Y/82/20/RES

Land to the south of Ford Lane and East of North End Road Yapton BN18 0DS

Comments

Harrogate

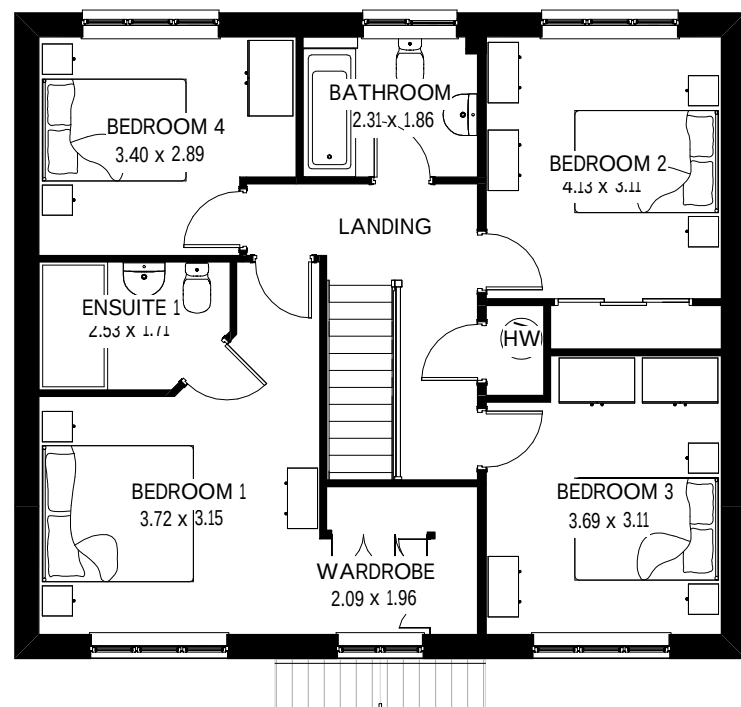
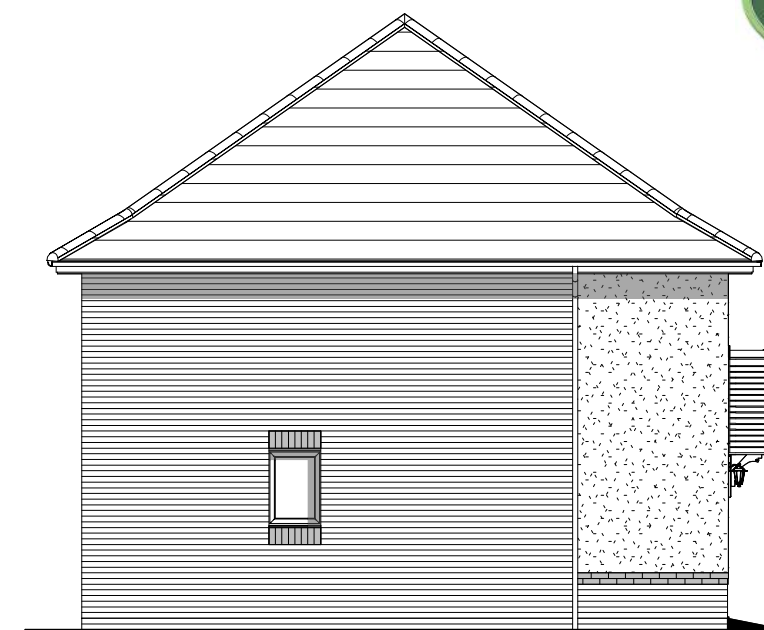
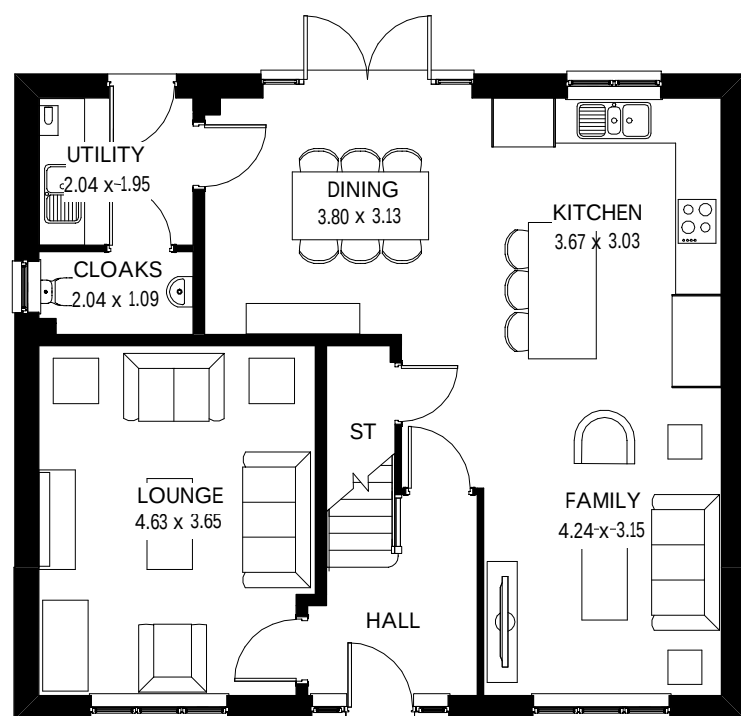
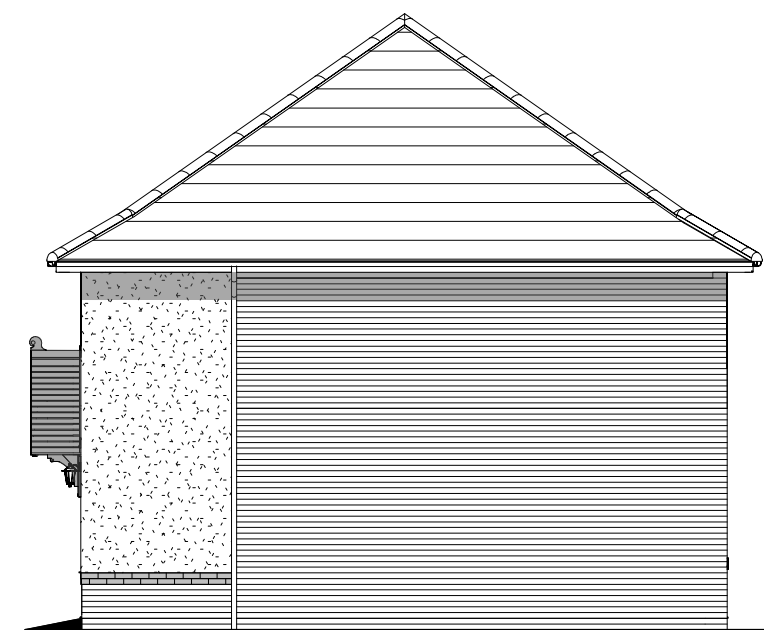
The design of the houses closest to the conservation area and church appear to be based on the designs of properties constructed in the early to mid C20. At present, the development along the northern side of Church Lane are of a similar age in terms of their construction date, so this approach would appear to be acceptable. Further, the designs are somewhat suitable for the character of the wider village, which grew substantially during the C.20. The success of such designs will ultimately depend upon the quality of the materials proposed, which should be carefully considered.
